Our Ref: LU/48/20/PL 19-02-2020

Demolition of 1 No. bungalow & outbuildings & erection of 22 No. dwellings with associated parking & open space. This application is a Departure from the Development Plan.

Southdown Nursery Old Mead Road Littlehampton

Thank you for your internet representation made on 23rd March 2020 which has been recorded as '**an objection**' with the comments as follows:

DRAWING TITLE
Proposed Site Layout Plan

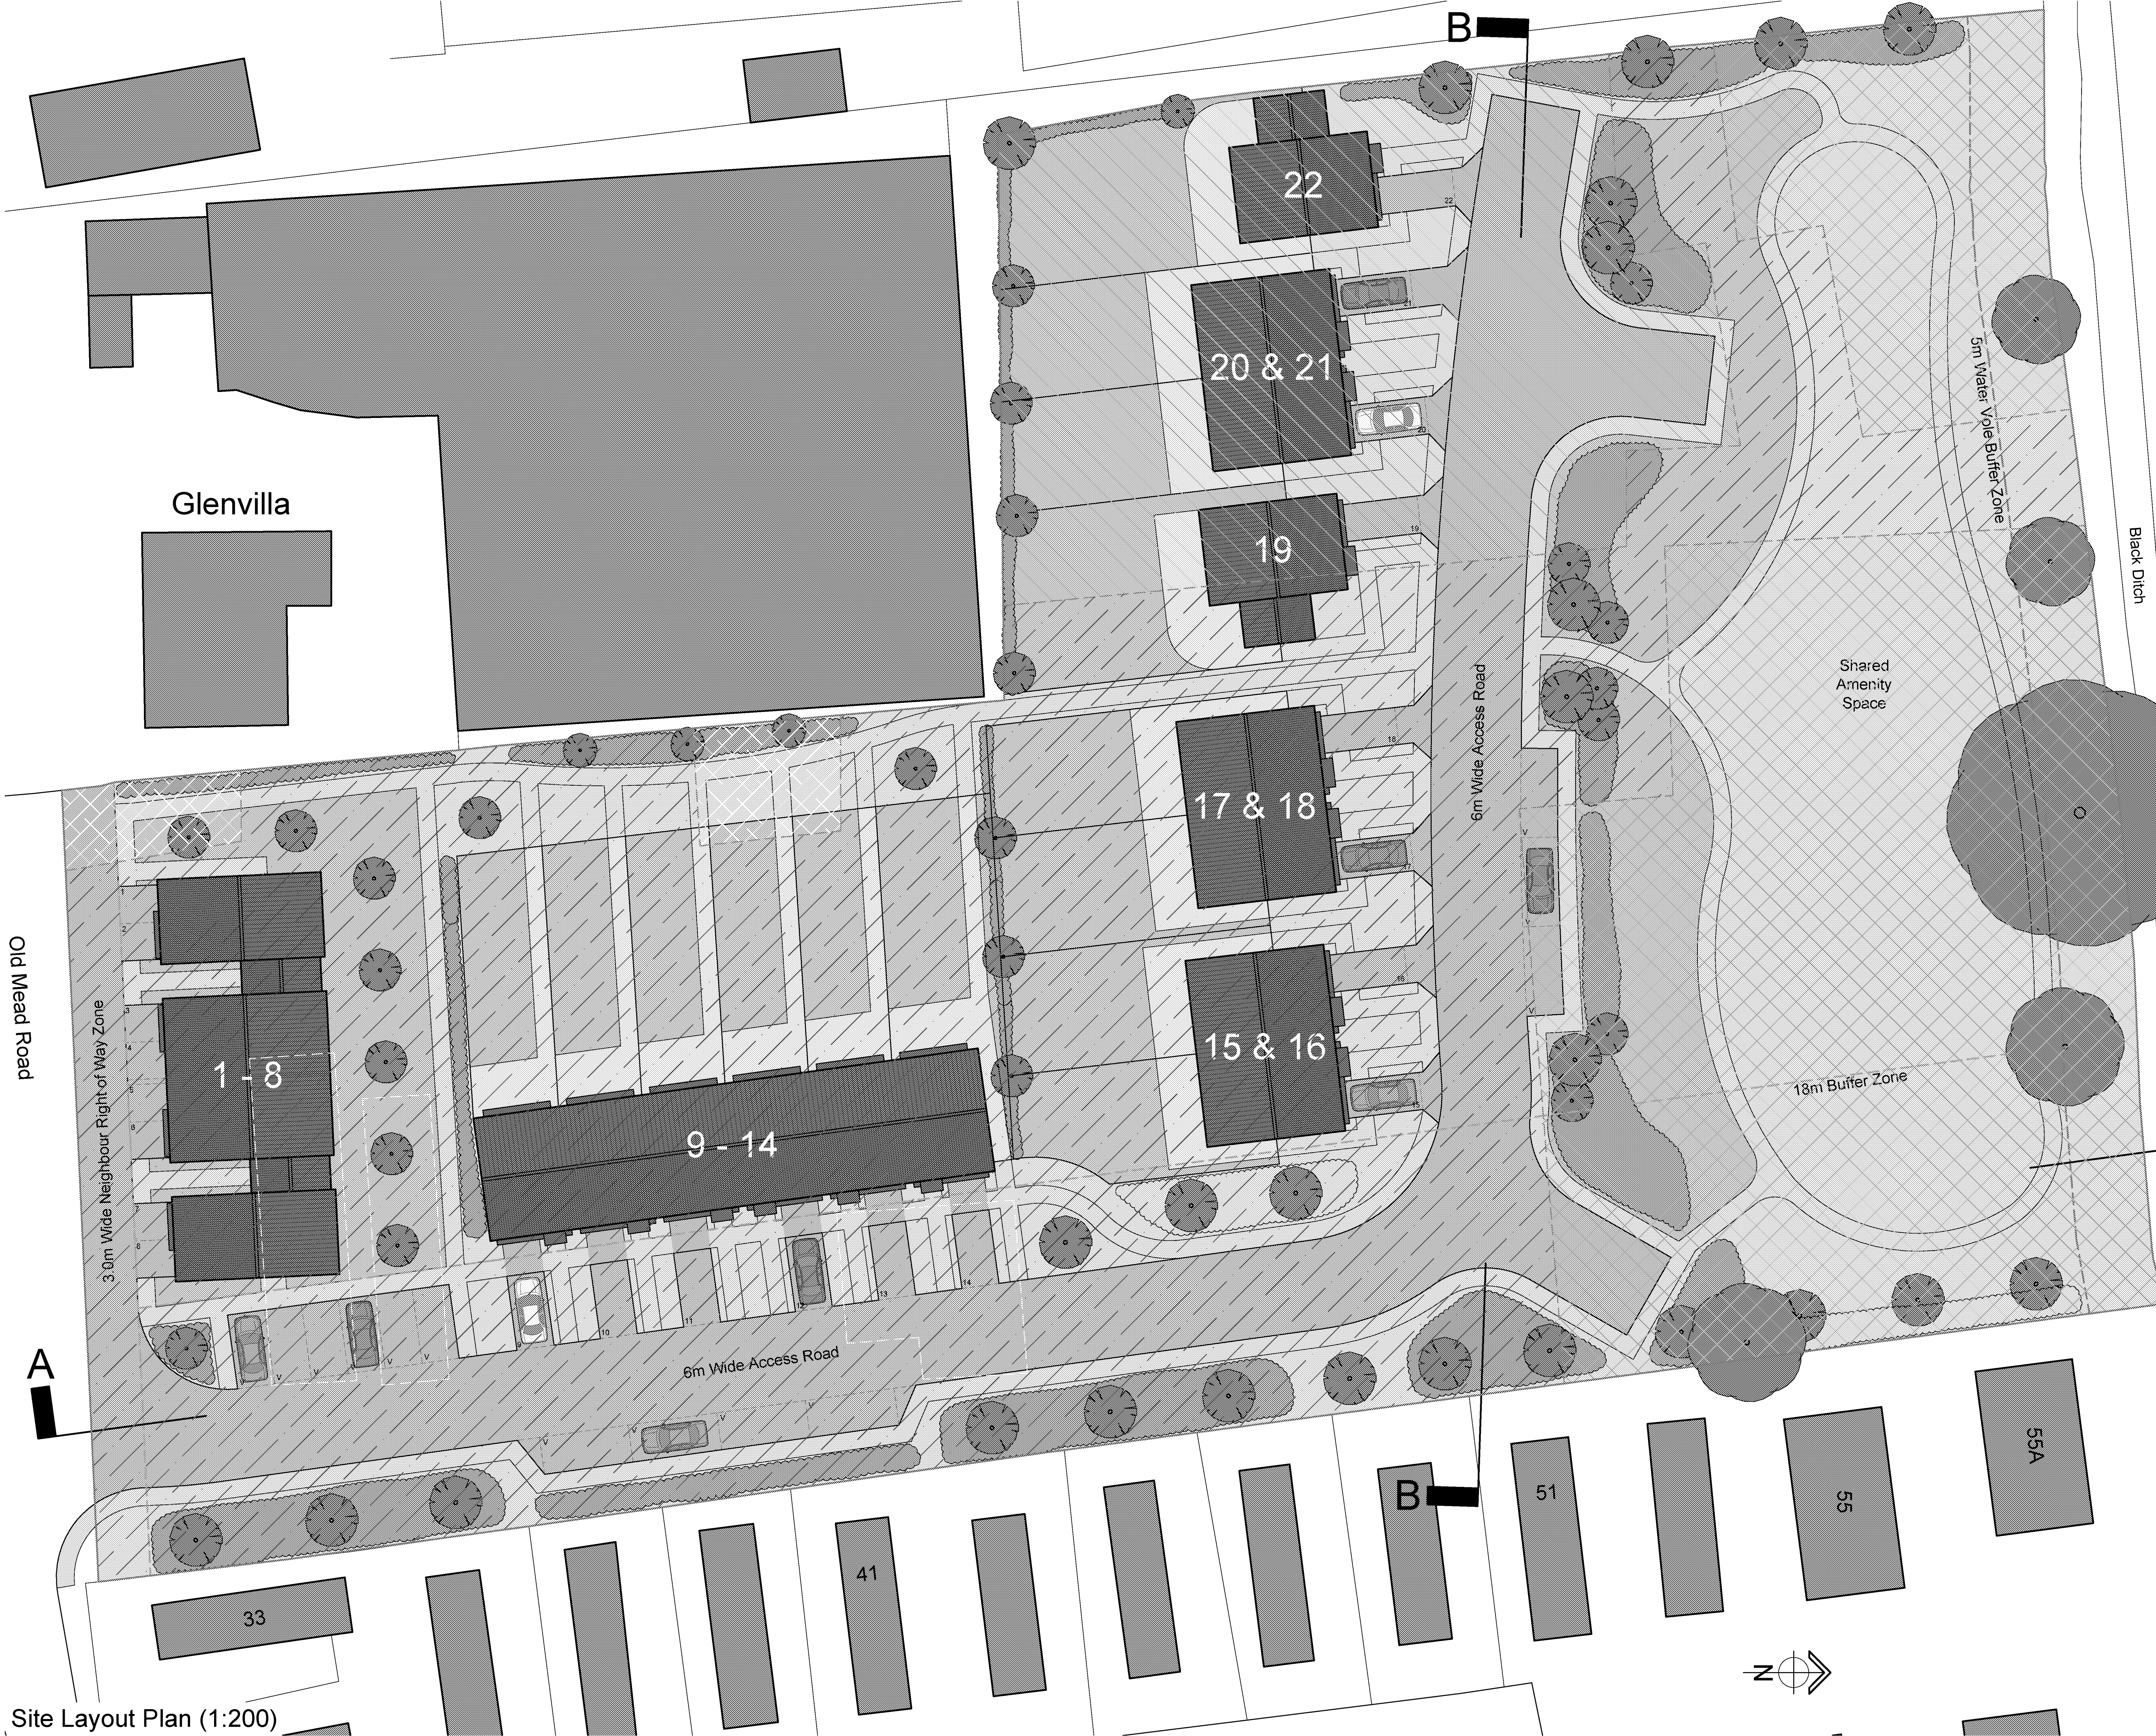
accommodate the larger vehicles that are becoming increasingly popular. Will there be enough room on properties 1 to 8 to park two such vehicles without the occupants having to resort to parking on the road/right of way?
